City of Portland, Maine - Building or Use Permit Application
 389 Congress Street, 04101 Tel: (207) 874-8703, Fax: (207) 874-8716

Permit No: 09-0656	Issue Date:	CBL: 225 E010001
------------------------------	--------------------	----------------------------

Location of Construction: 386 CAPISIC ST	Owner Name: WAYFARER VILLAGE INC	Owner Address: 143 CRAIGIE ST	Phone:
Business Name:	Contractor Name: Larry Dontello	Contractor Address: P.O. Box 684 P Portland	Phone 2072327220
Lessee/Buyer's Name	Phone:	Permit Type: Single Family	Zone:

Past Use: Vacant Land	Proposed Use: Single Family - Construct a ranch style single family home/ partial daylight basement, 2 car garage, porch & Deck	Permit Fee: \$1,395.00	Cost of Work: \$130,000.00	CEO District: 3
Proposed Project Description: Single Family - Construct a ranch style single family home/ partial daylight basement, 2 car garage, porch & Deck		FIRE DEPT: <input type="checkbox"/> Approved <input type="checkbox"/> Denied	INSPECTION: Use Group: Type	
		Signature:	Signature:	
PEDESTRIAN ACTIVITIES DISTRICT (P.A.D.)				
Action <input type="checkbox"/> Approved <input type="checkbox"/> Approved w/Condition <input type="checkbox"/> Denied

PROJECT NAME: 386 Capritz
FORTIN RESIDENCE

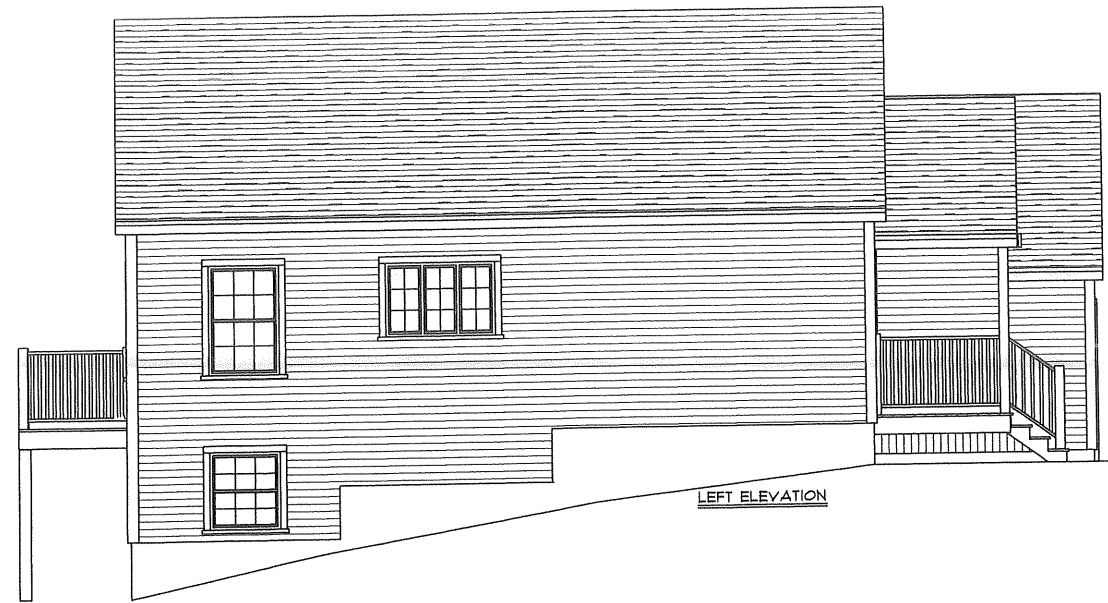
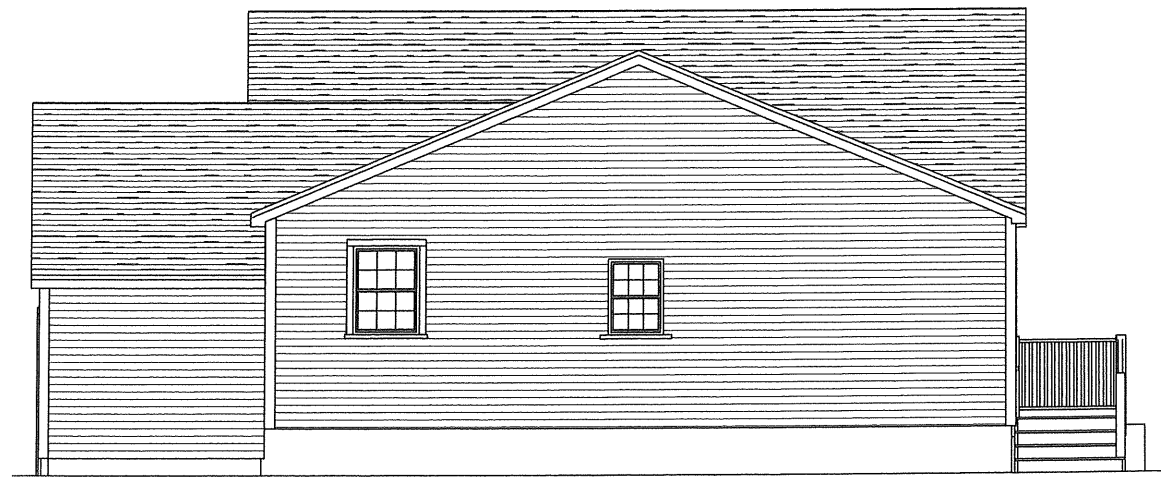
6/26/2009-amachado: Spoke to Jim Gray. The rear deck on the building plan does not match the rear deck on the site plan. Jim said that the building plan is correct and that he will amend the site plan. I'm moving the permit forward in the system but I won't sign off until the siteplan is amended.
